OXFORDSHIRE COUNTY COUNCIL'S RESPONSE TO CONSULTATION ON THE FOLLOWING DEVELOPMENT PROPOSAL

Application no: 21/04157/F

Proposal: Use of the site for the storage of operational vehicles, together with elevational and site alterations, associated parking, welfare facilities, vehicle barrier and associated infrastructure

Location: Banbury 200, Southam Road, Banbury

TRANSFORMER DETAILS
 1:50

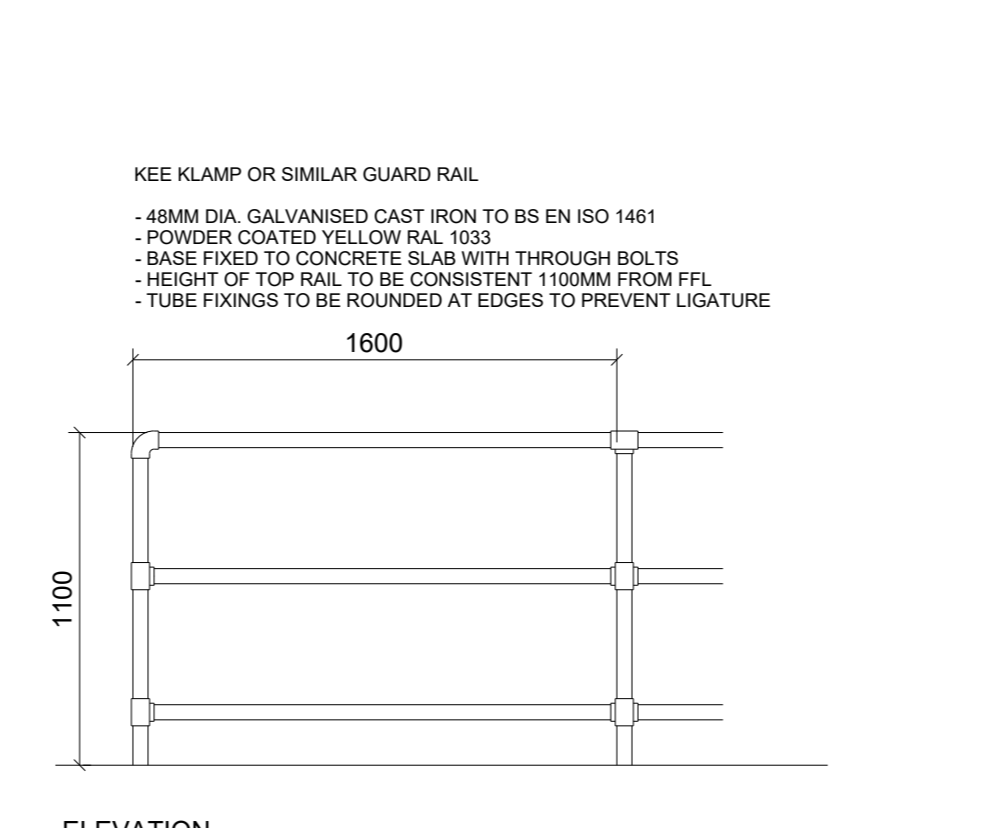
My only concern is whether the infrastructure to be provided for van charging is suitable for charging the private electric cars which will be parked there in the daytime. Policy EVI 8 of the Strategy says:

If the charging infrastructure is suitable for cars, then the figure will be 100%. However, if it is not suitable for cars, then appropriate facilities will have to be provided in at least 25% of the bays, and this should be conditioned as necessary. 21/00503/F seems to make no mention of private EV charging so, strictly speaking, I presume the 25% would apply just to the additional 156 spaces. In the interests of long-term sustainability, the availability of private EV charging should be considered across the whole site.

PROPOSED SITE PLAN
1:500

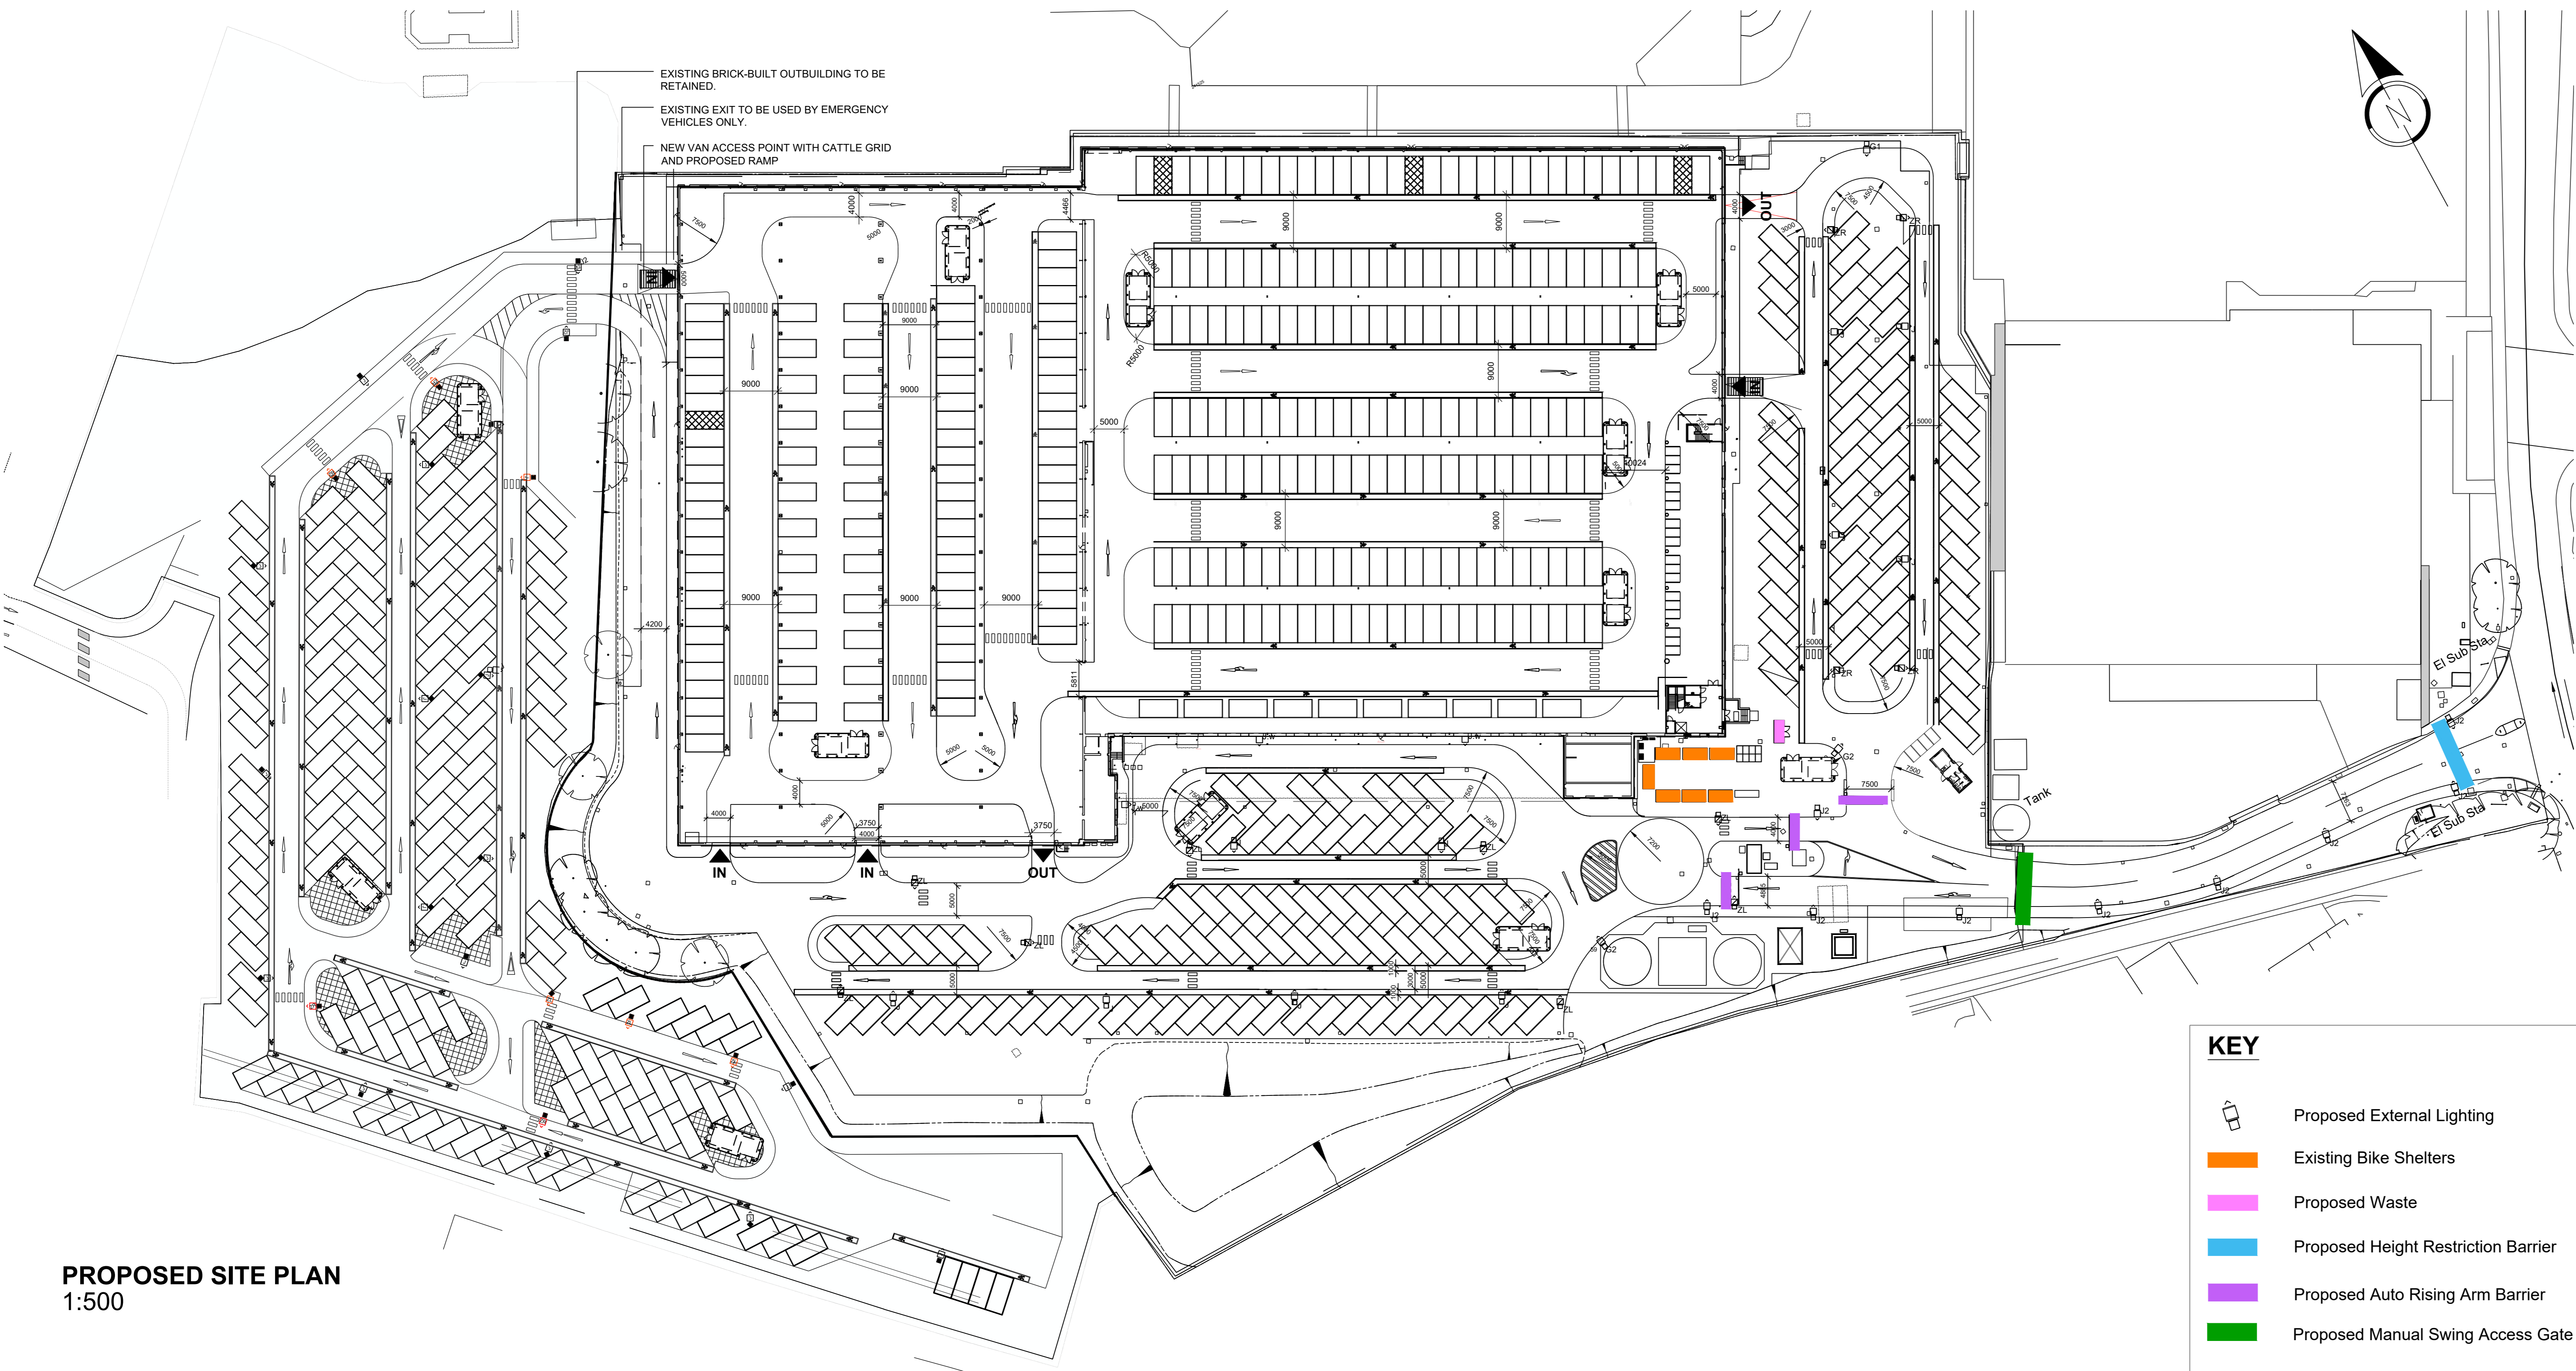
“Planning permission will only be granted for non-residential development that includes parking spaces if a minimum of 25% of the spaces are provided with electric charging points.”
